Historic England

**APPLICATION BY ANGLIAN WATER SERVICES LIMITED FOR AN ORDER
GRANTING DEVELOPMENT CONSENT FOR THE CAMBRIDGE WASTE-WATER
TREATMENT PLANT RELOCATION PROJECT
APPLICATION REF: WW010003**

**REPRESENTATIONS OF THE HISTORIC BUILDINGS AND MONUMENTS
COMMISSION FOR ENGLAND (HISTORIC ENGLAND)**

# Photomontage 1: View north-east from High Ditch Road

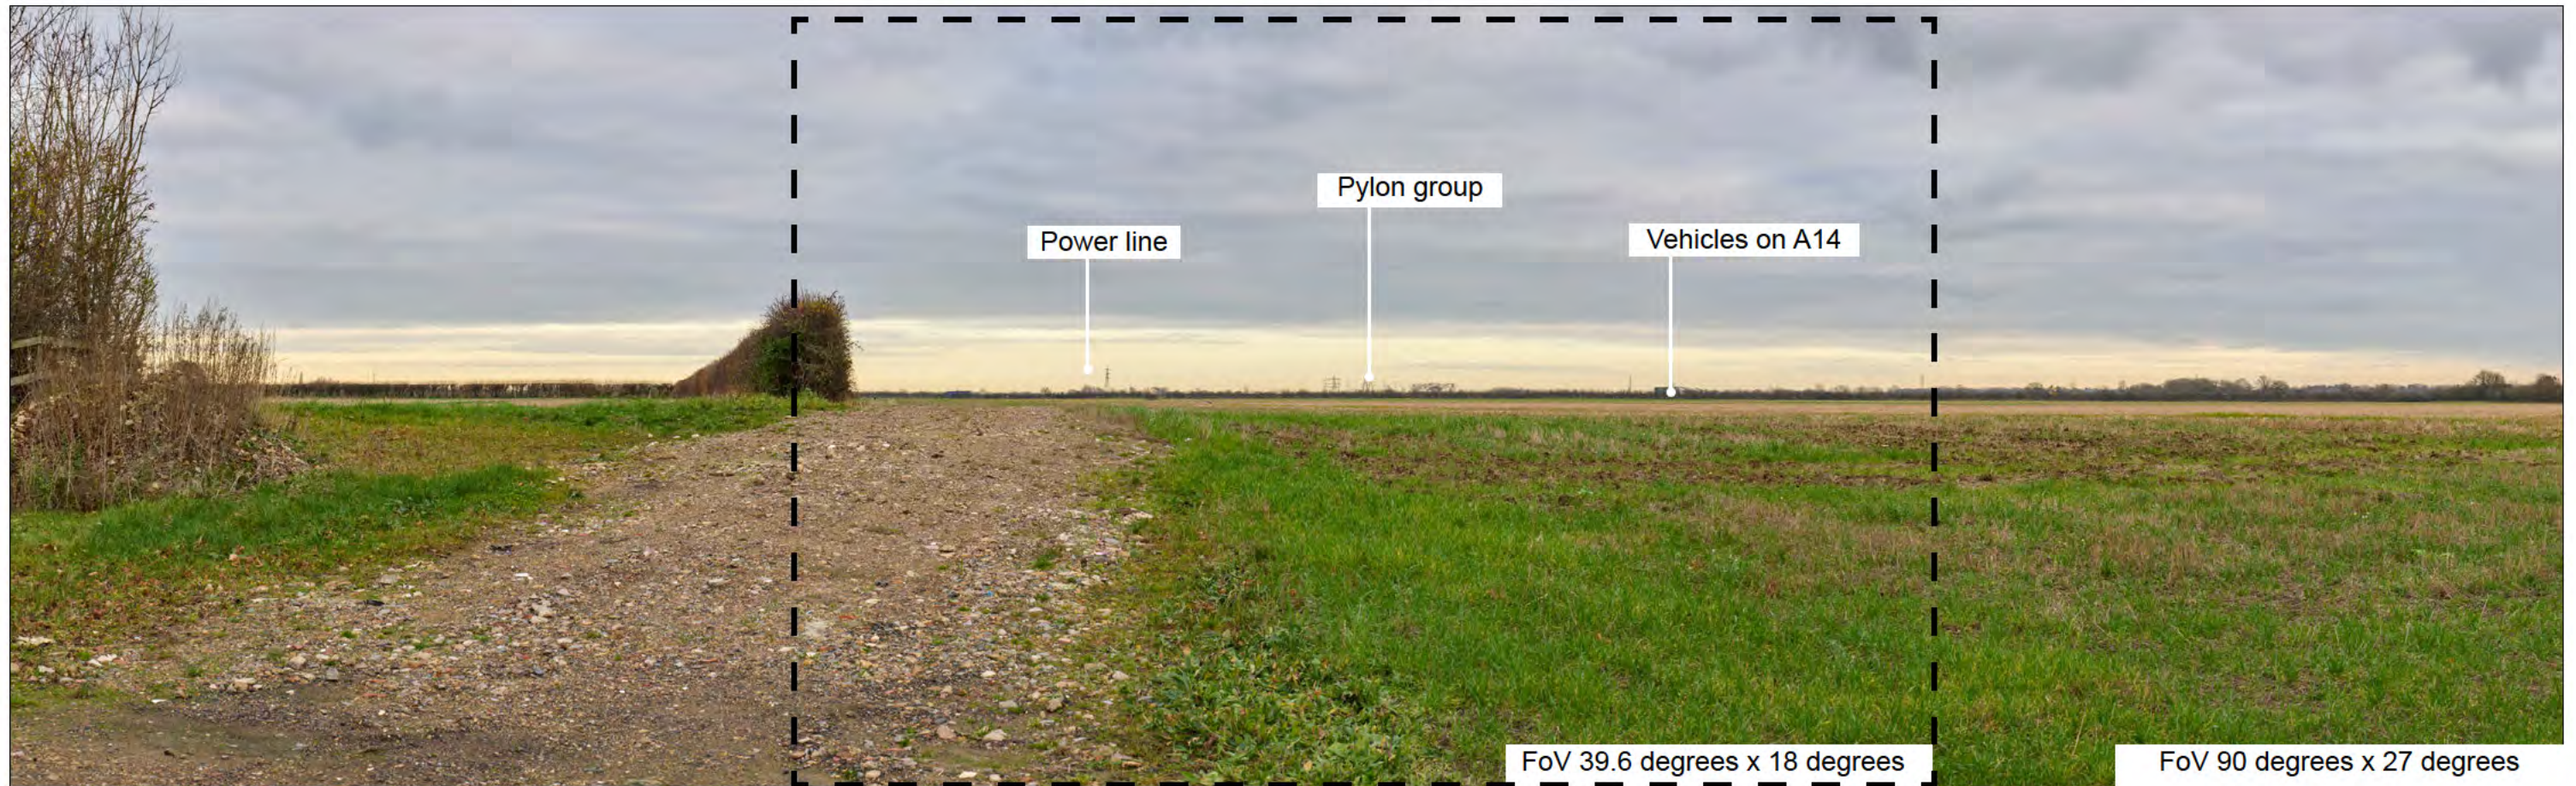
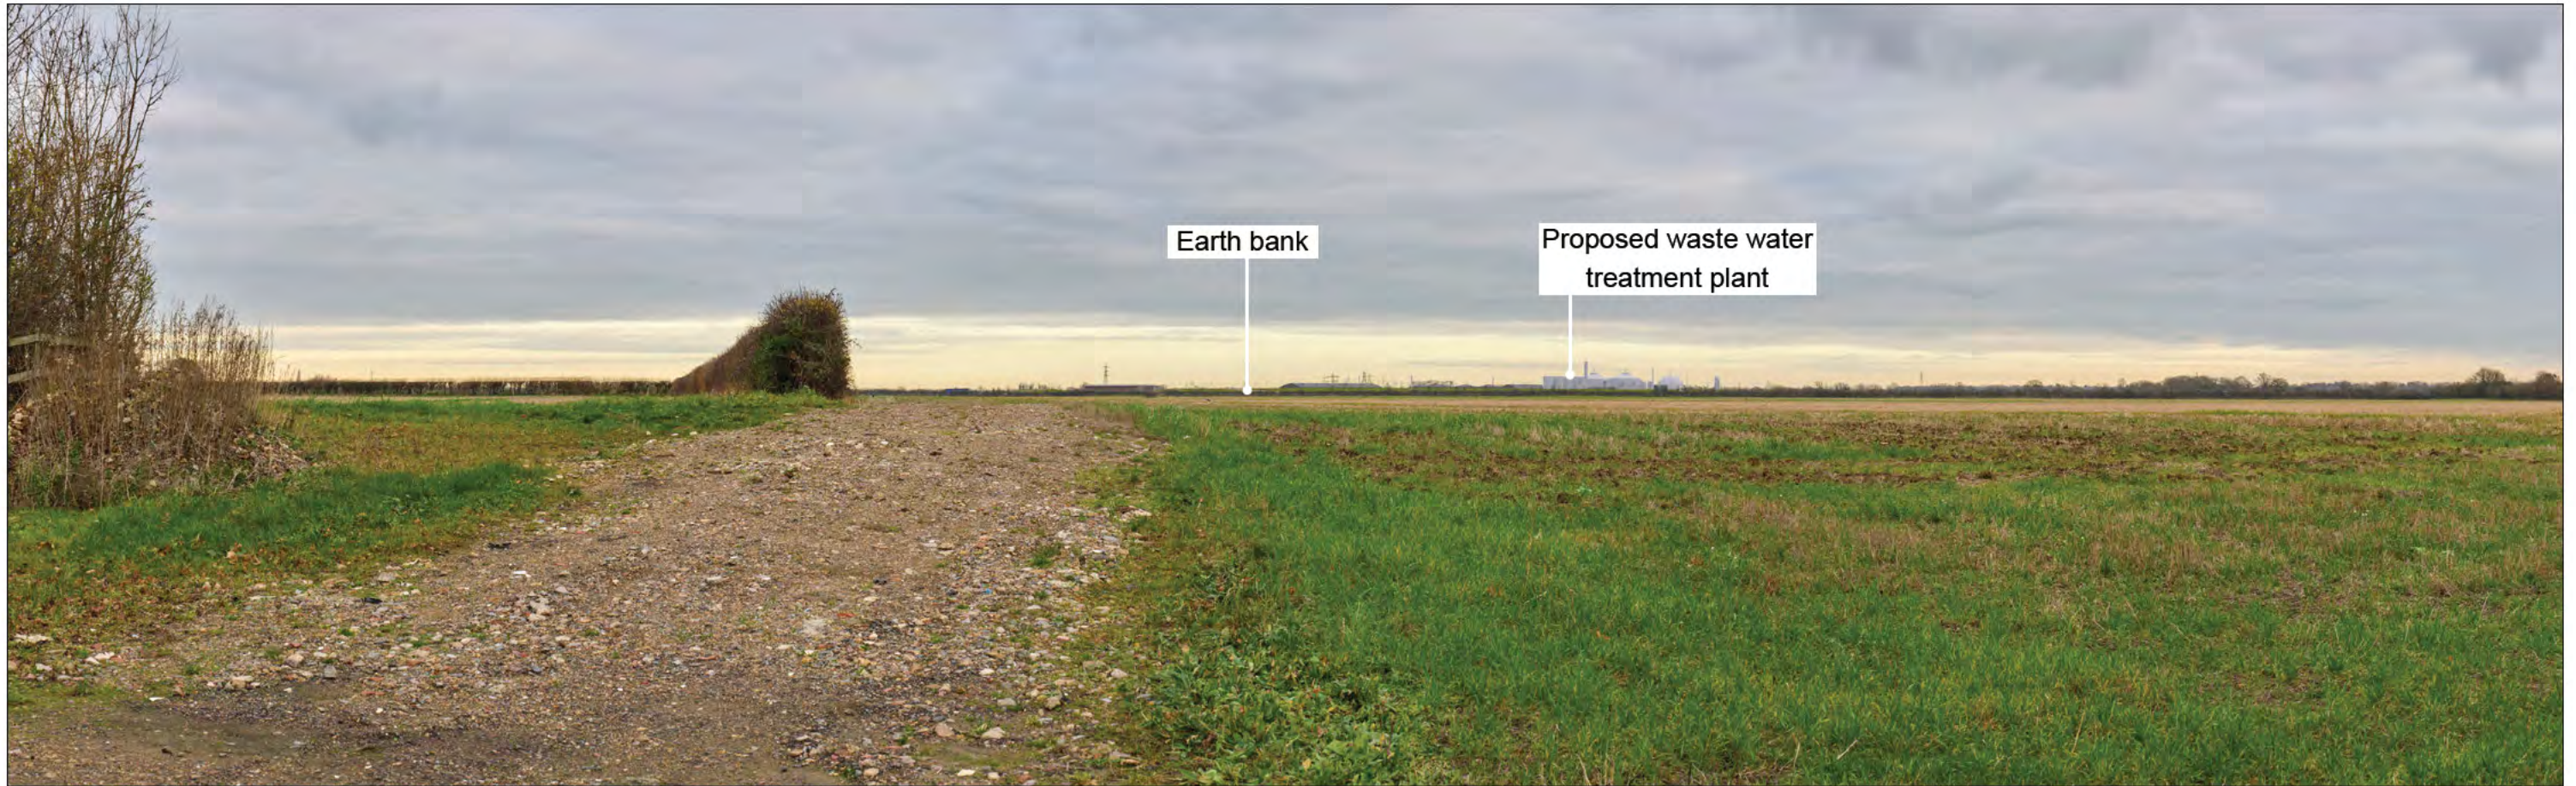
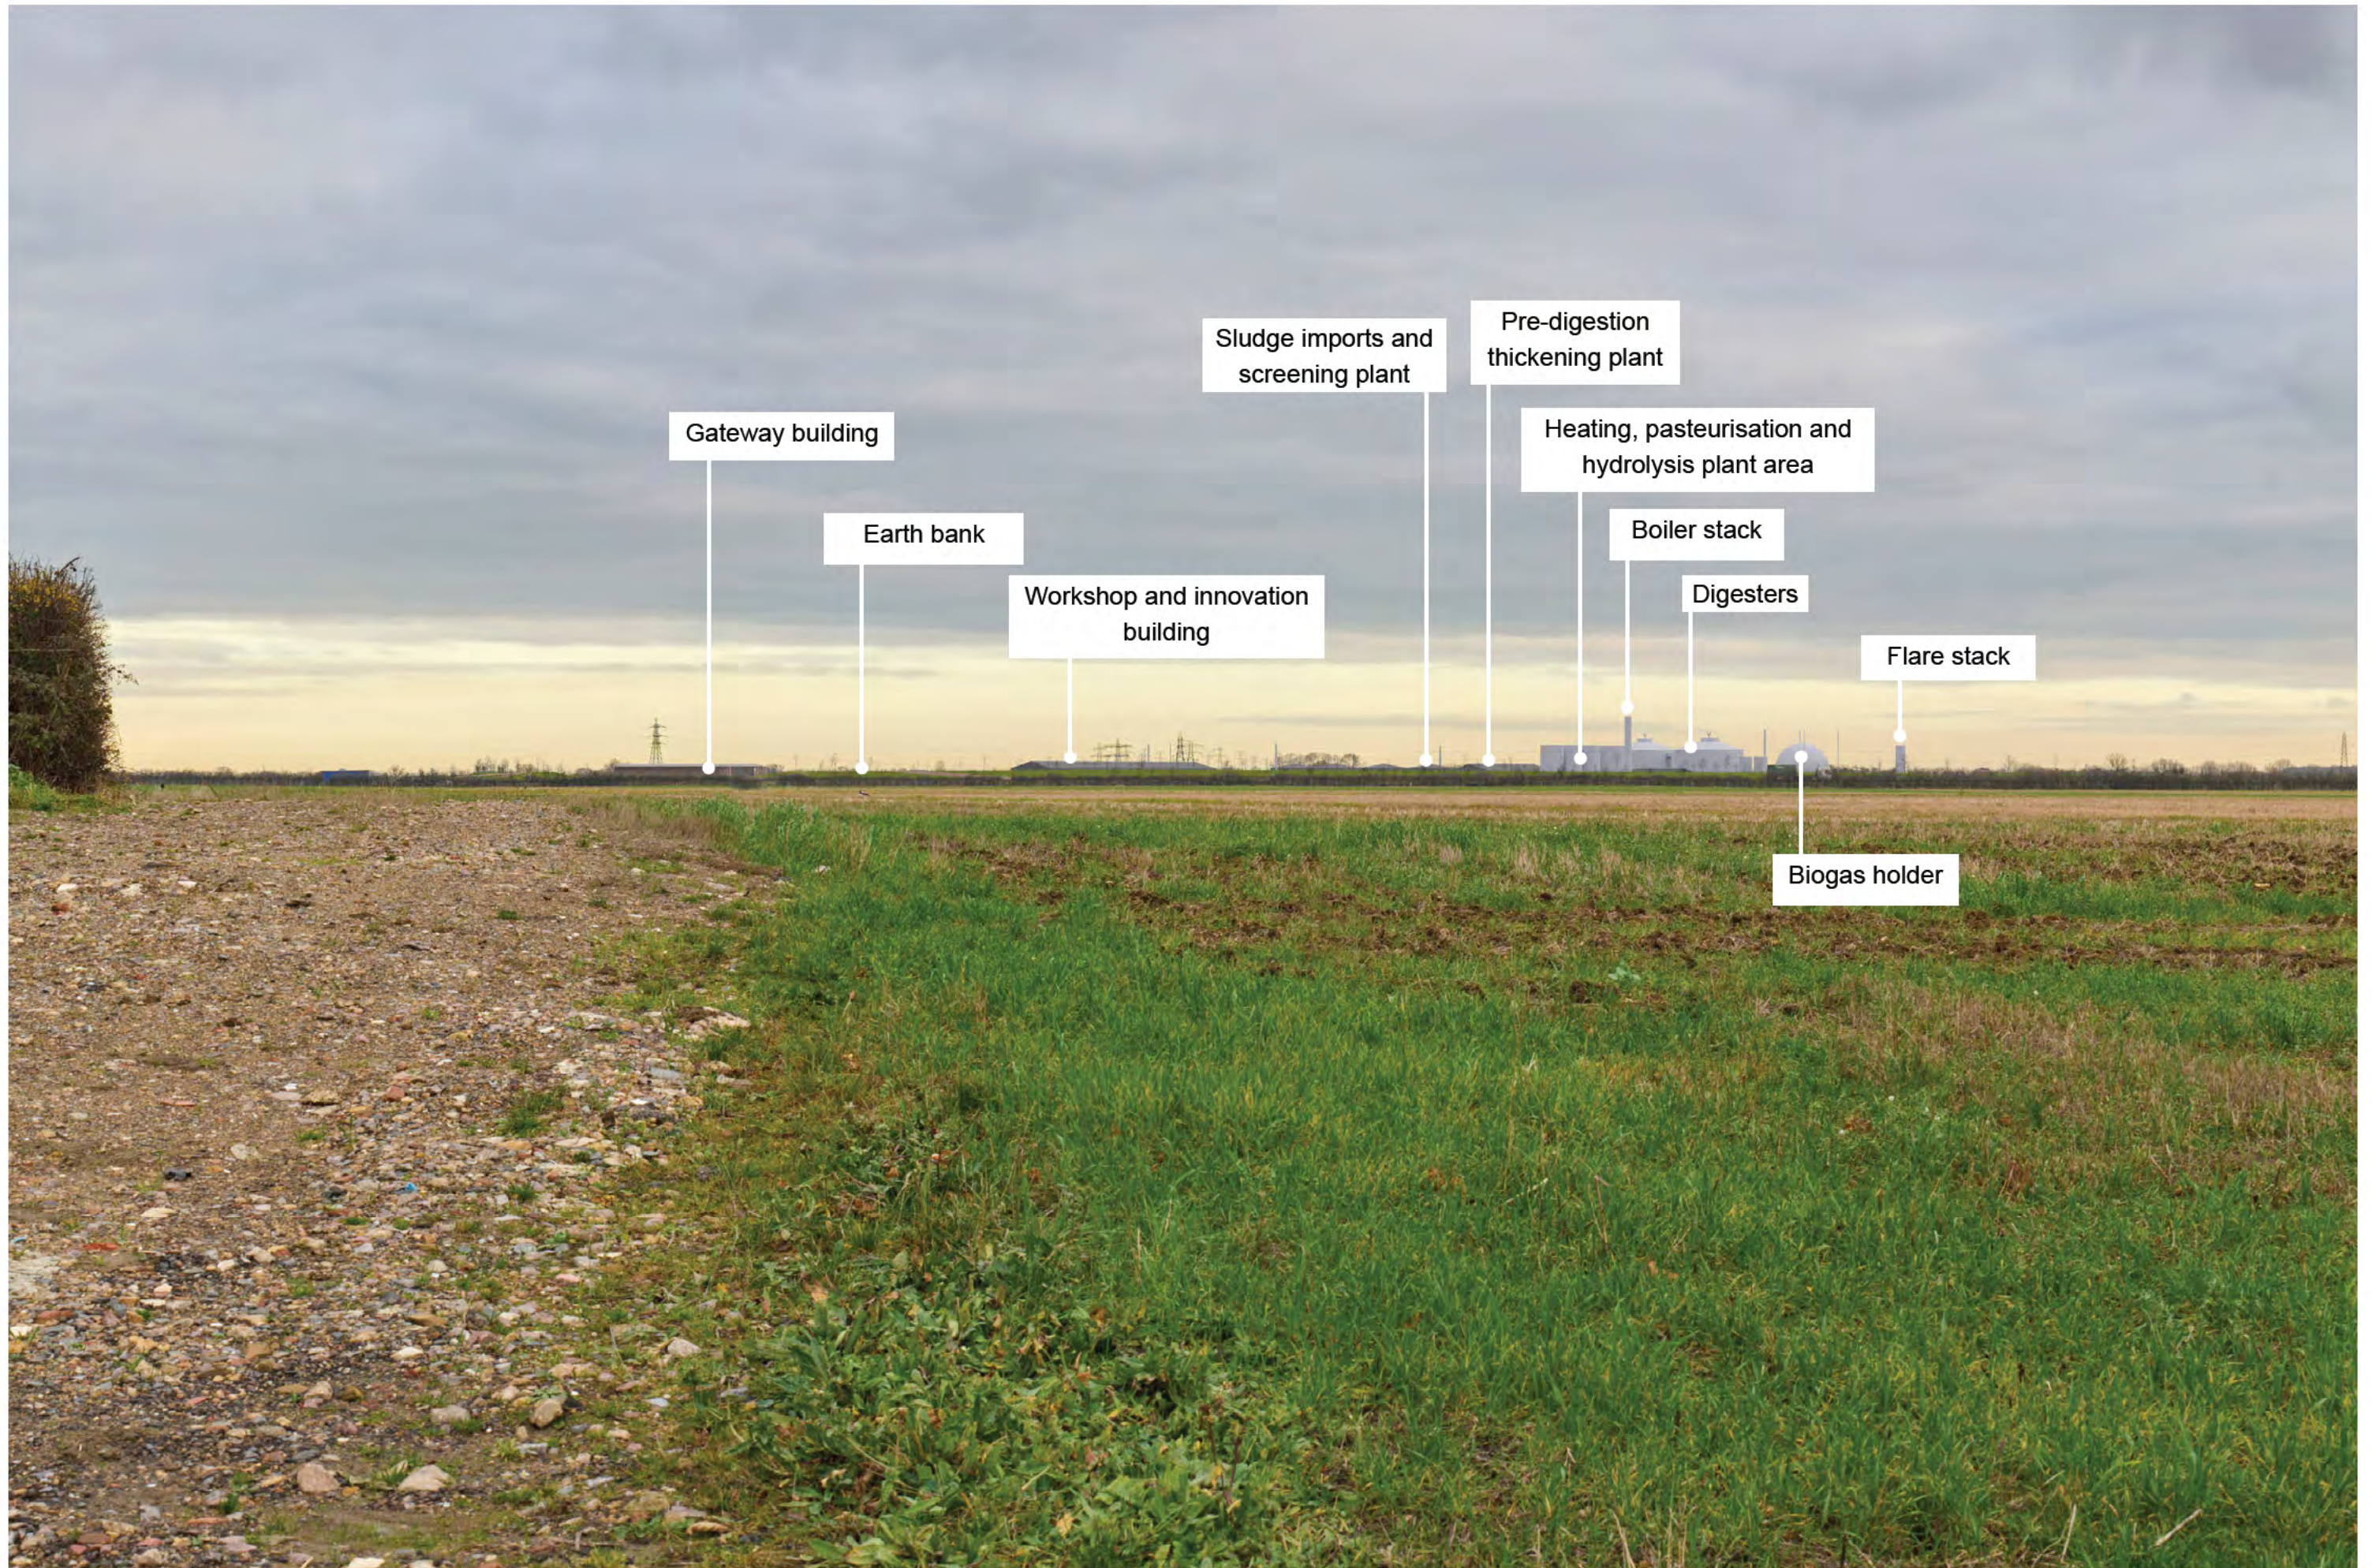
- 2.17. The presence of the proposed facility, which includes various structures of significant scale will result in a fundamental change to the setting of those heritage assets that we have identified. We believe that the facility would therefore be apparent in views from both Bait's Bite (easterly views) and Fen Ditton Conservation Areas (northerly views from High Ditch Road); as well as in easterly views towards the site that take in Biggin Abbey – as demonstrated in the submitted photomontages -particularly images 1 and 2.
